City of Albuquerque Stormwater Construction Site Inspection Report

ESC File No.	G14E097	Project Name:	Calle Cuarta
NPDES Id. No.	NMR1005D6	Location:	3525 4th St NW
12/14/2023	Owner	Contractor	
Operator	Yes Housing, Inc.	Pavilion Construction	
Contact name & title	Page Ollice	Jared McCarn	
e-mail	pollice@yeshousing.org	jmccarn@pavilionconstruction.com	
Contact Phone #	505-923-9607	505-668-8854	
COA Inspector	Chancellor English	Start/End Time:	1015am
Construction Phase:	grading		
Type of Inspection:	Regular	Storm Event	Post Storm Event >0.25"
		311/Complaint	Follow Up
Weather at time of inspection?	Rain	Temperature: ~	45
Estimated date of last storm 0.25" or greater	12/14/2023

YES CALLE CUARTA TH, LLC
CALLE CUARTA RESIDENTIAL
SUBDIVISION
TESCP - PWO

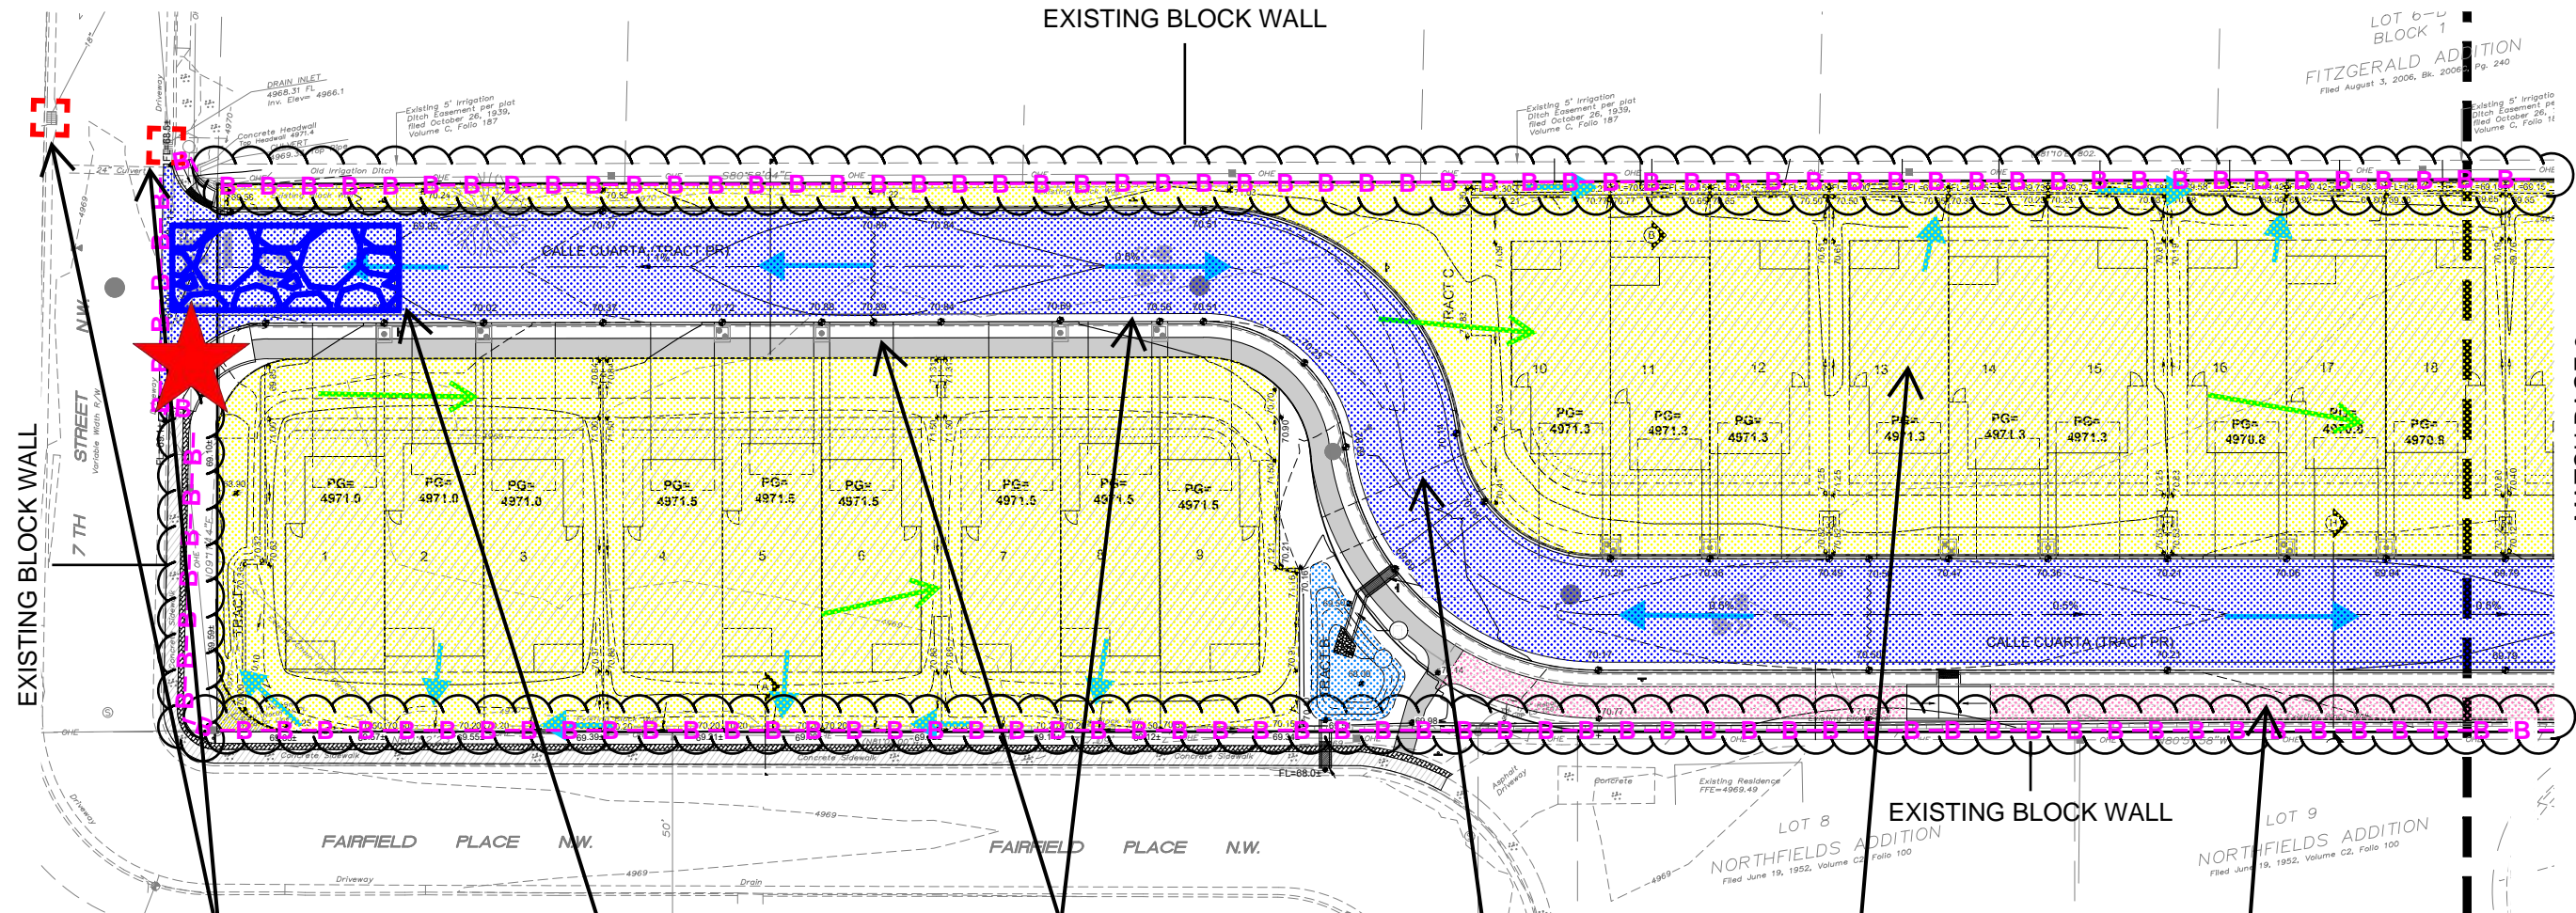
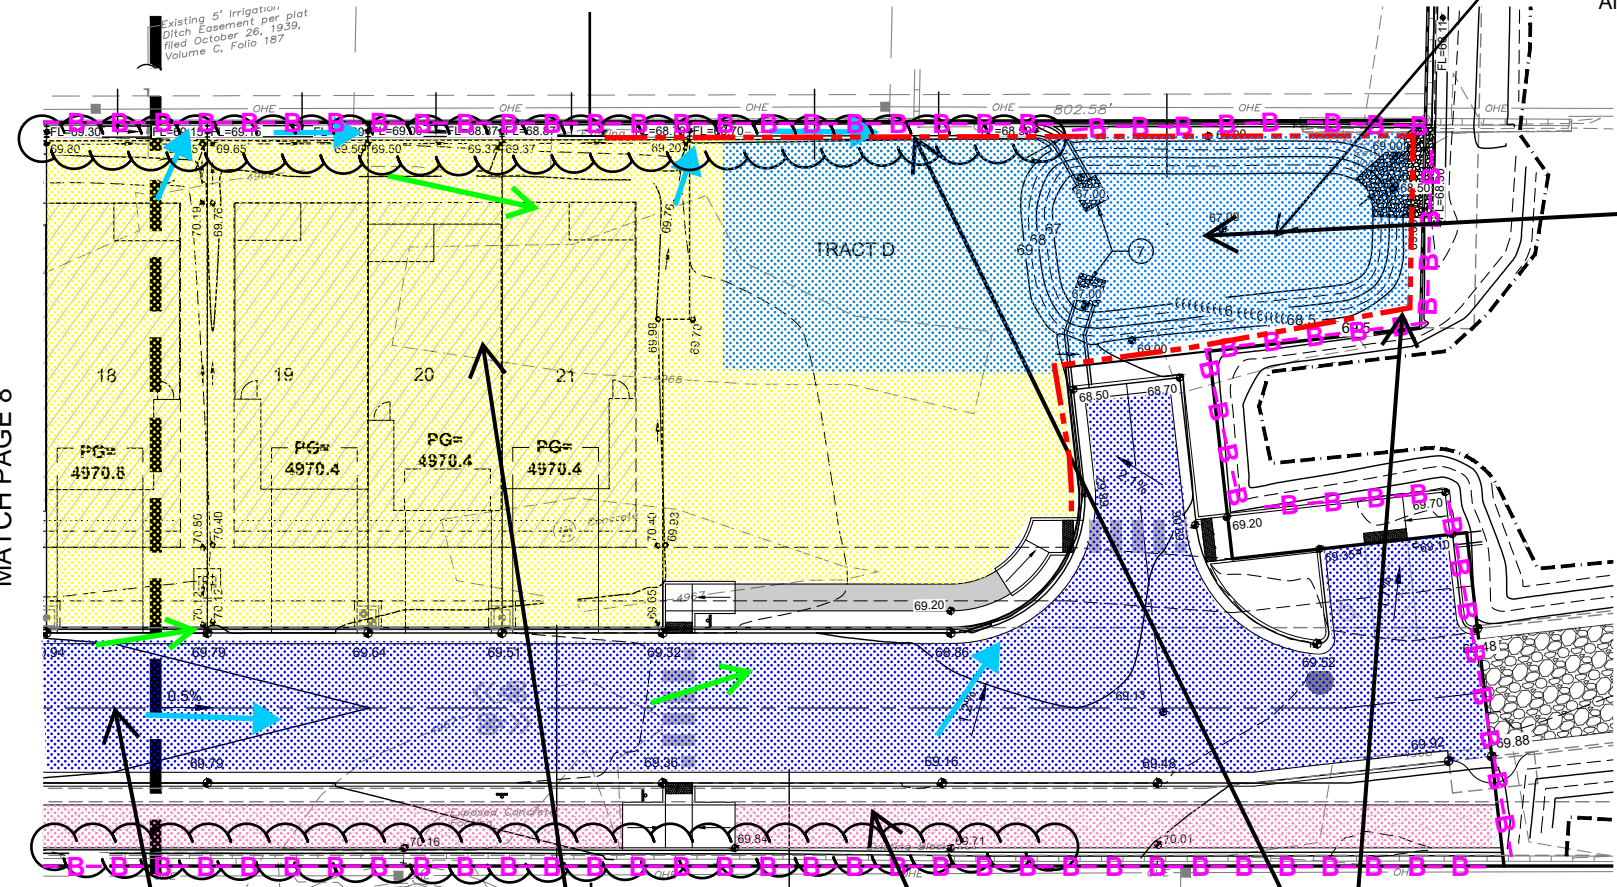
Item Number	Deficiency/ Corrective Action		
1	BMPs - The silt fence along Fitzgerald Rd. is still not entrenched in violation of CGP Part 2.1.2. There are no perimeter stormwater controls along the neighboring property (504 Fitzgerald Rd.) in violation of CGP Part 2.2.3. Required Mitigation: You must install all stormwater controls in accordance with good engineering practices, including applicable design specifications per CGP 2.1.2. Silt fencing requires entrenching in order to be an effective stormwater control. Install sediment controls along any perimeter areas of the site that are downslope from any exposed soil or other disturbed areas per CGP Part 2.2.3. The elevated pads that have been installed mean the perimeter is downslope of the disturbed soil.		
2	SWPPP - The self-inspection reports were unavailable at the time of the inspection in violation of CGP Part 4.7.3 and City Ordinance § 14-5-2-11. The SWPPP Map needs to be updated to reflect the current on-site conditions regarding the construction fenced area on the neighboring property in violation of CGP Part 7.4.1. Required Mitigation: At a minimum, a routine compliance self-inspection once every 14 days and after any precipitation event of ¼ inch or greater until the site construction has been completed and the site has been determined as stabilized by the City per City Ordinance § 14-5-2-11 and CGP Part 4.2. You must keep a copy of all inspection reports at the site or at an easily accessible location, so that it can be made immediately available at the time of an on-site inspection per CGP Part 4.7.3. You must modify your SWPPP, including the site maps, within seven days you make changes to your construction plans, stormwater controls, or other activities at your site that are no longer accurately reflected in your SWPPP per CGP Part 7.4.1. Amend the site map to reflect the current boundaries of the construction site.
